Application for a Non-Material Amendment Following a Grant of Planning Permission

Land adjacent to Plough Lane, Leavenheath, CO6 4PH

Erection of 2no. detached dwellings

DC/22/00821

Project: Proposed Erection 2no Detached Dwellings at Land Adjacent to Plough Lane, Leavenheath, Essex, CO6 4PH		
Drawing Details: Proposed Street Scene, Garage Plans/Elevations & Site Plans		
Date: Jan 2022	Scale/s: See Drawing @ A1	Drawn: SGW
Number: 384-103	Rev: B

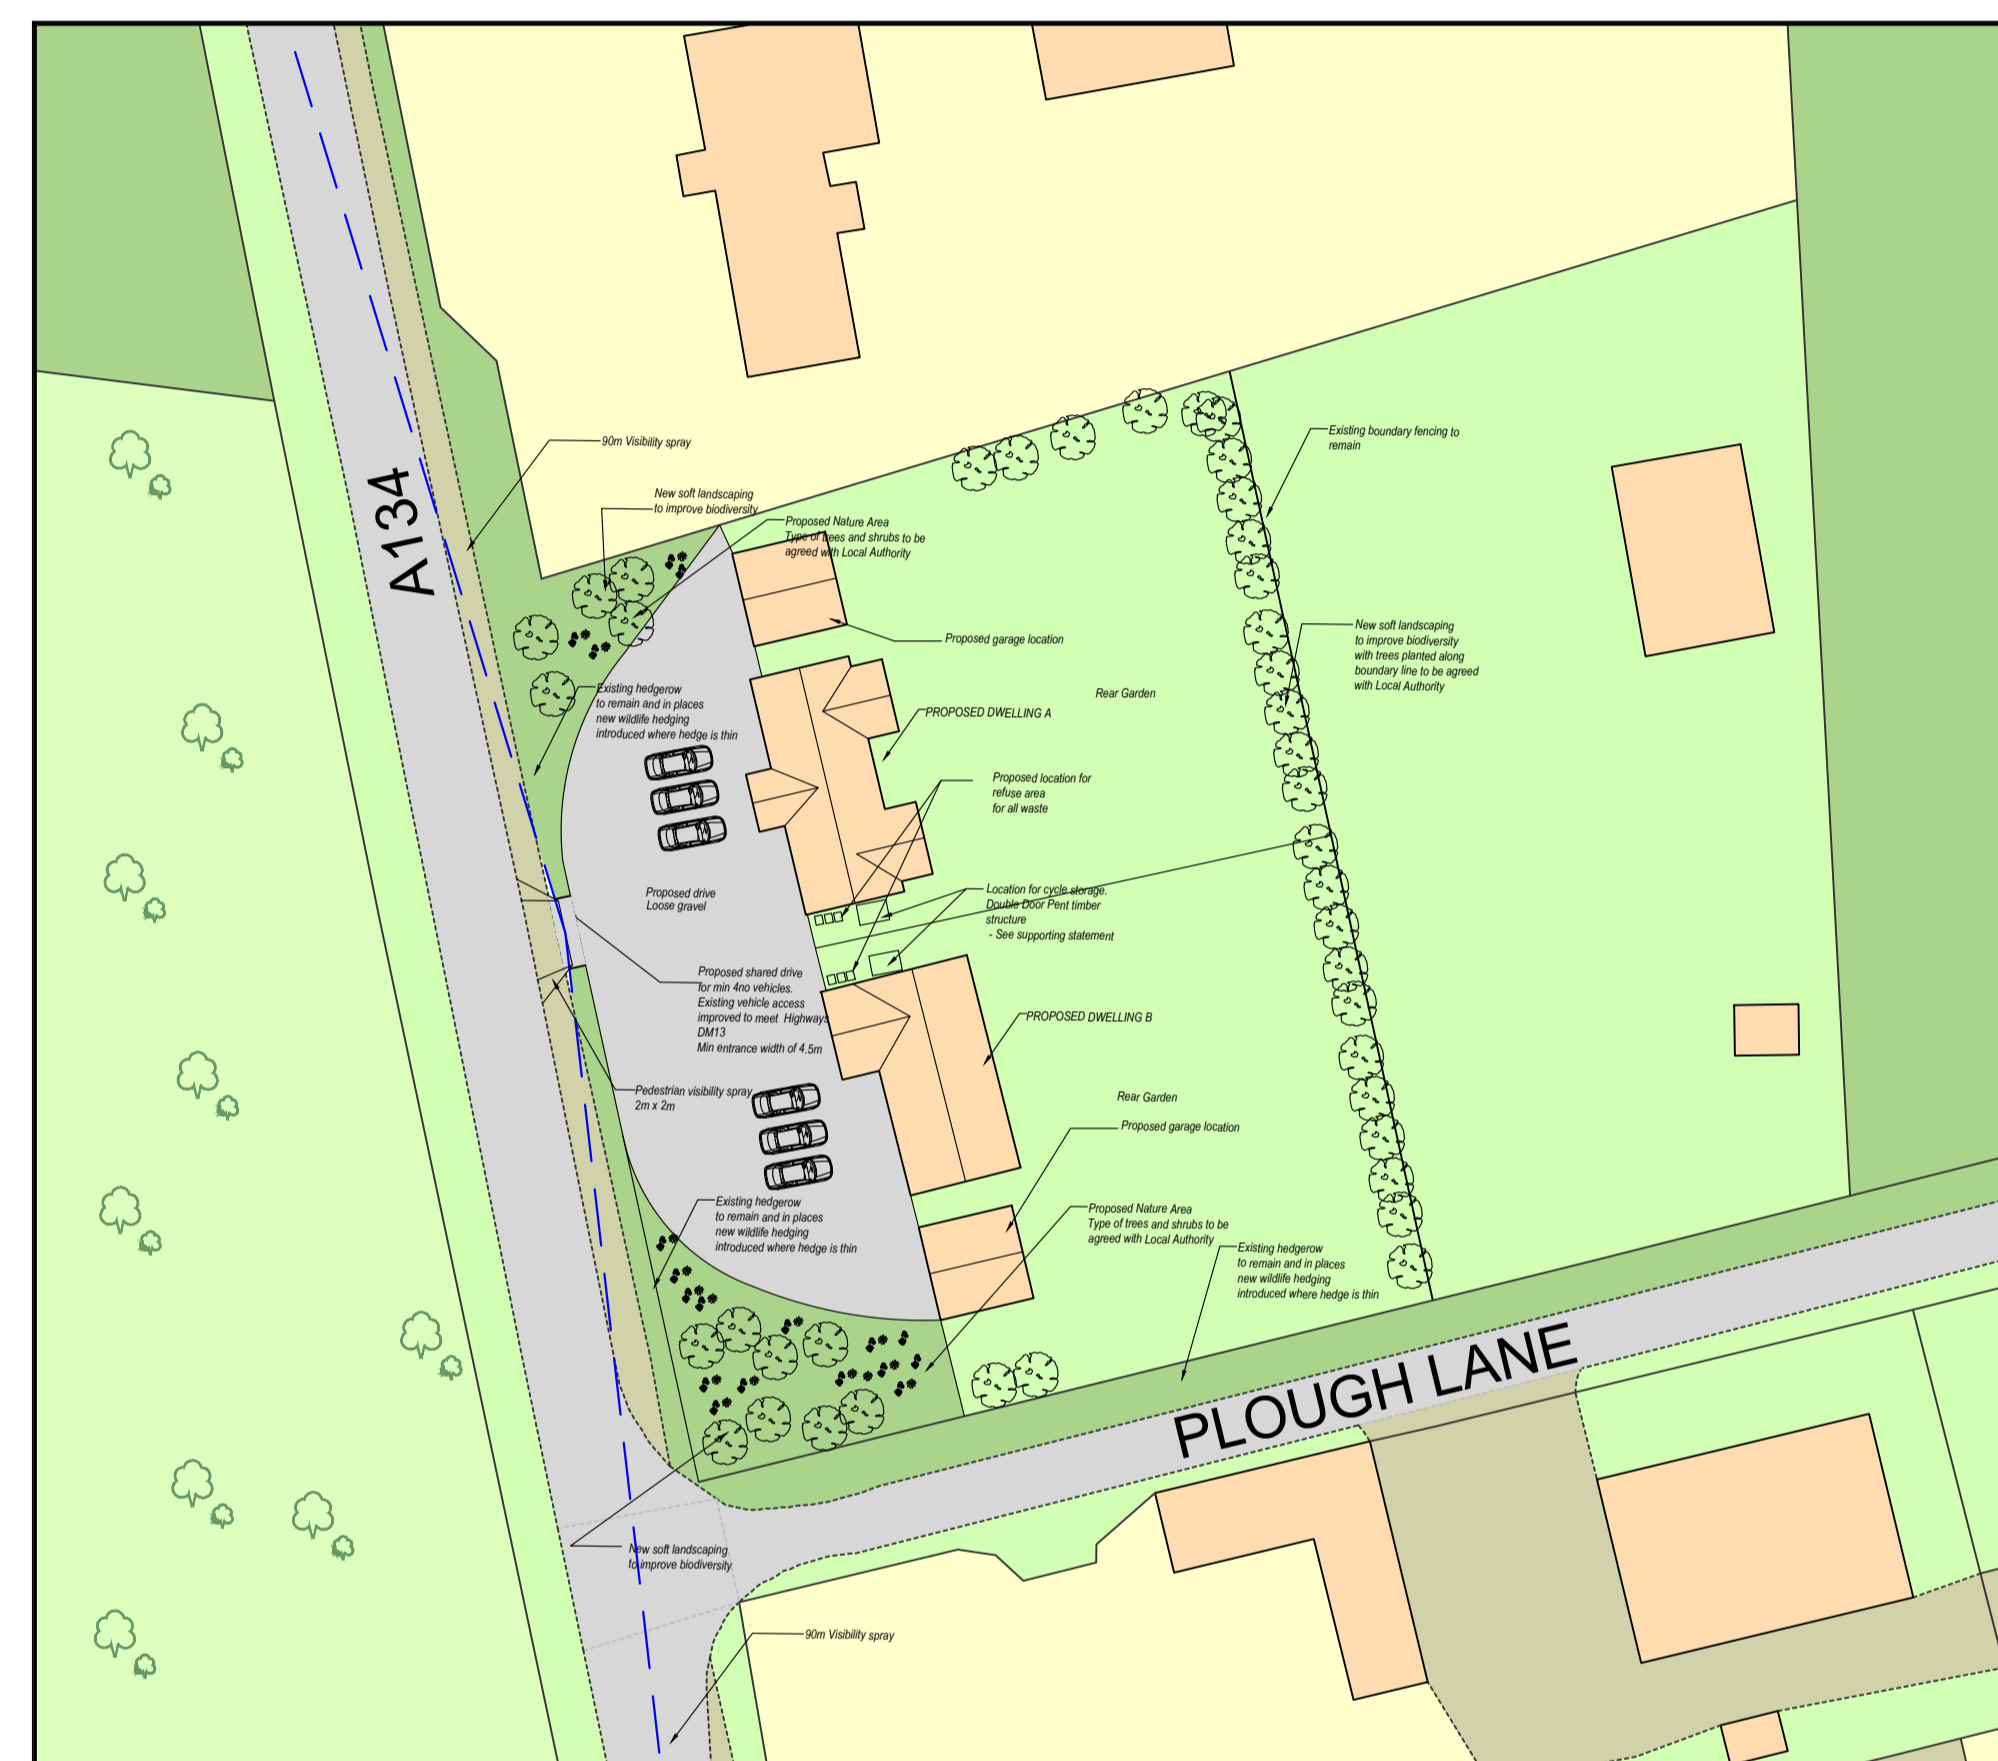
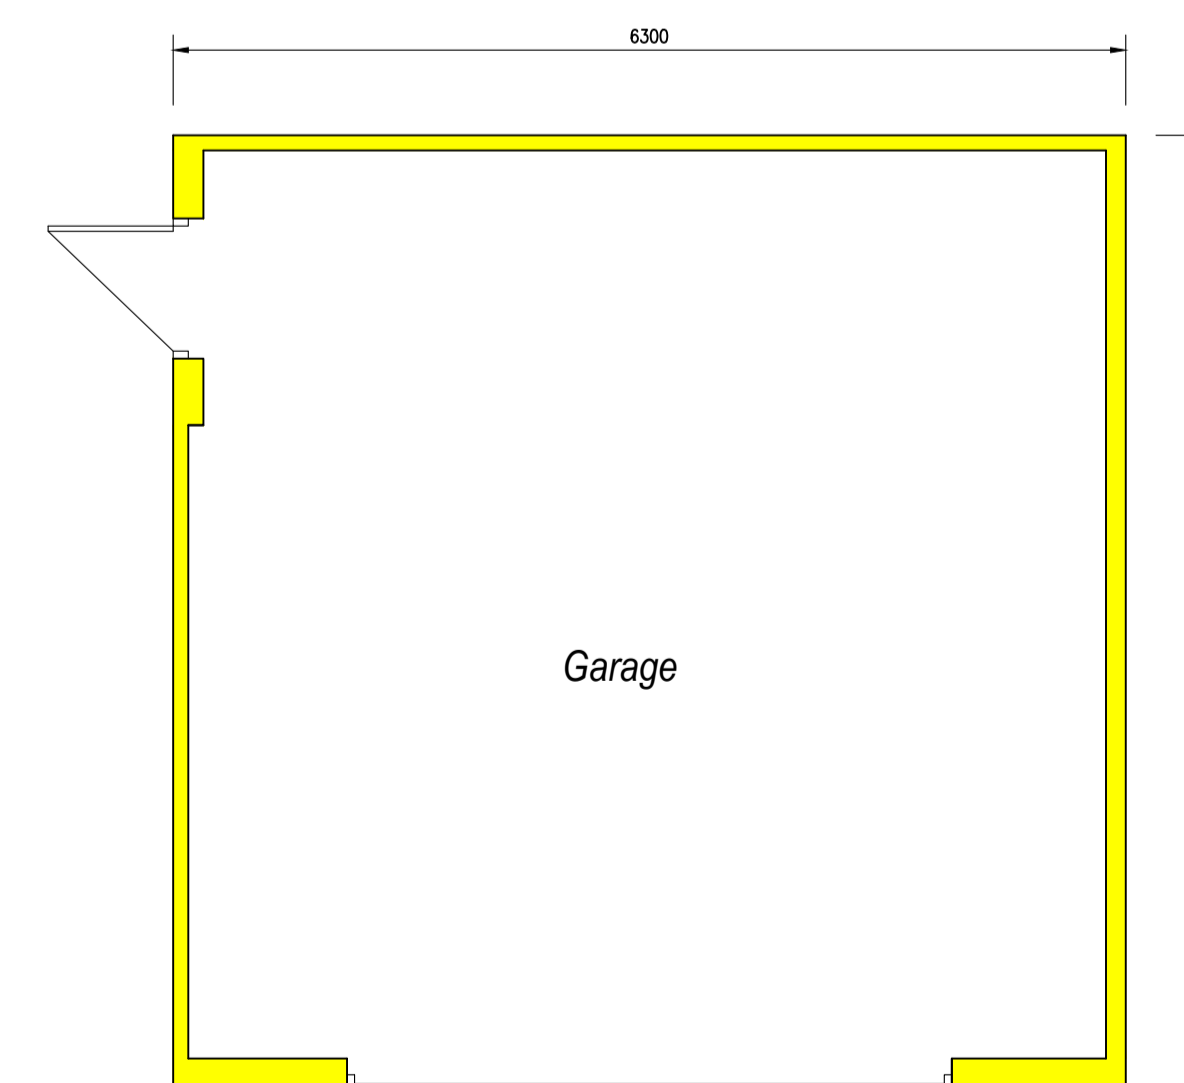
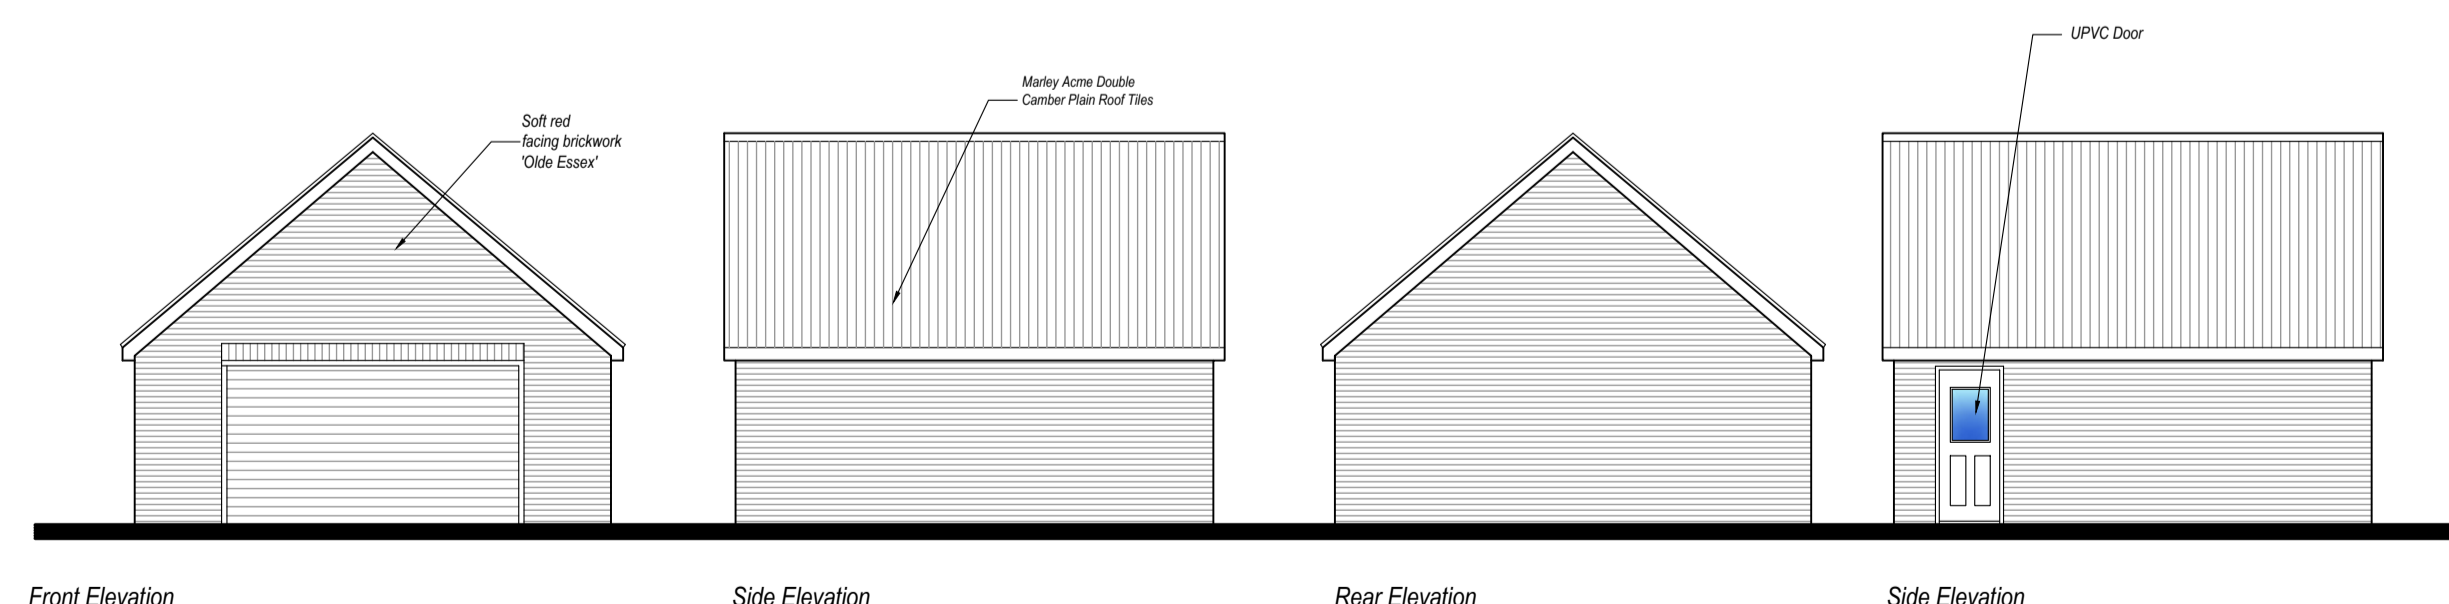
Relocation of dwellings as shown on drawing 384-103B swapped position
Chimney relocated on dwelling A
Single garages changed to double garages for each dwelling
